**WEST SUSSEX COUNTY COUNCIL
INFRASTRUCTURE CONSULTATION**

DATE: 03/11/2008

**SUBJECT: FP/217/08- Conv and COU of existing residential care home to 4 x private flats
(Resub of FP/99/08)**

4, Felpham Road, Bognor Regis, West Sussex

Drawing	Scale	Date	Drawing No.
LOCATION PLAN	1:200; 1250	OCT 08	9270/PL2/01
SITE/BLOCK PLAN

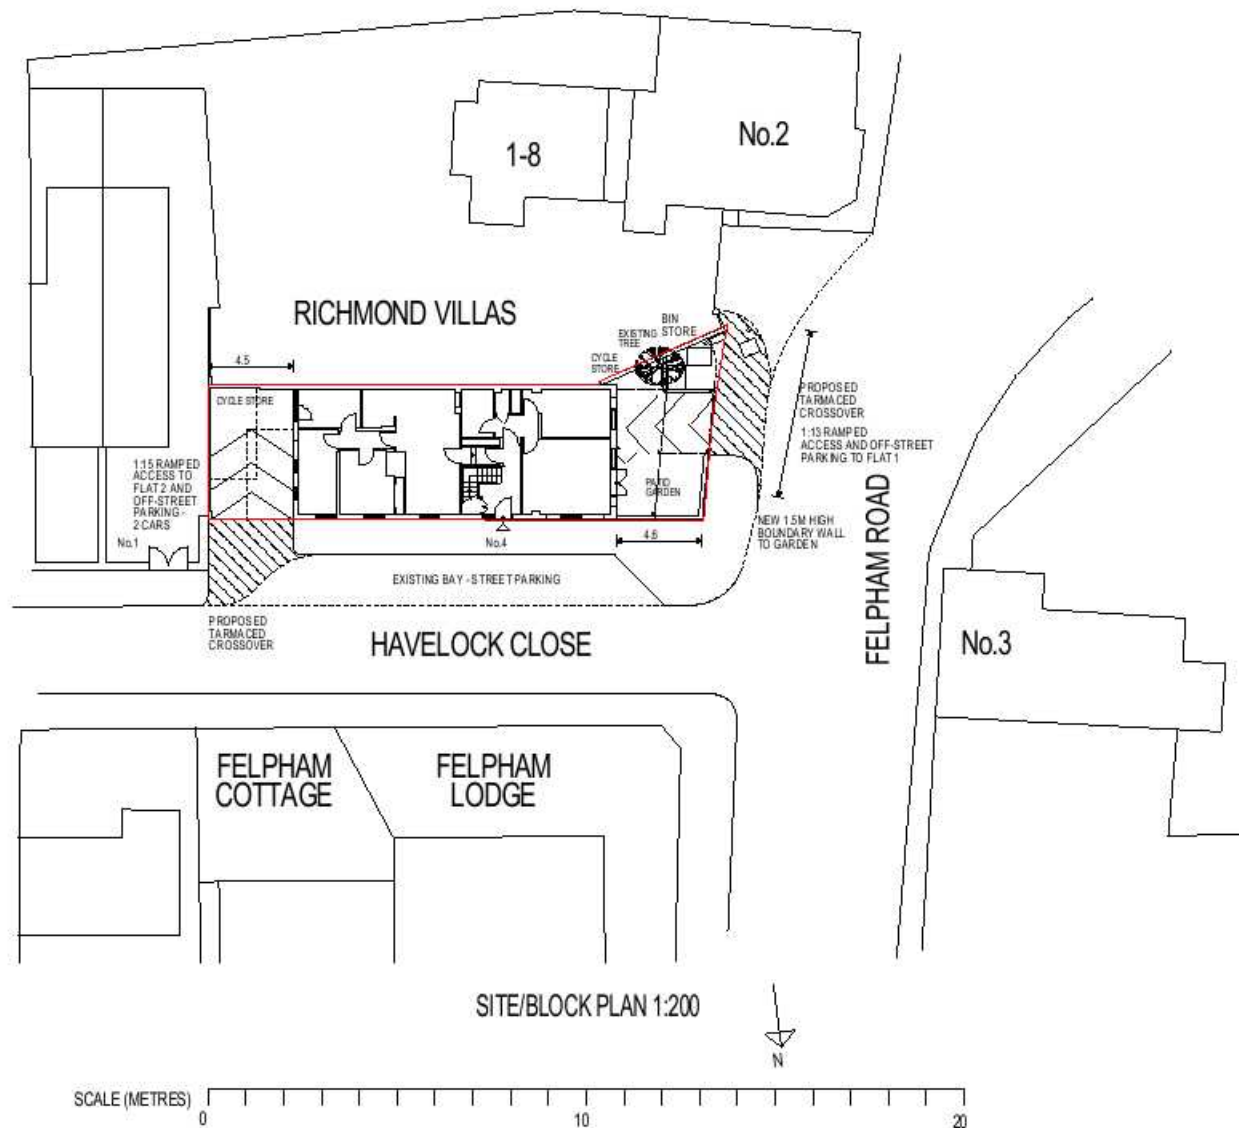
Cycle parking should be included, if not already available. This must be secure, covered and be capable of storing at least one cycle per bedroom of the converted building. The actual details of the cycle parking facilities should be submitted to and approved by the Local Planning Authority (LPA).

No dwelling, hereby approved, shall be occupied until covered secure cycle parking spaces have been provided in accordance with a detailed construction plan to be submitted to and approved by the planning authority.
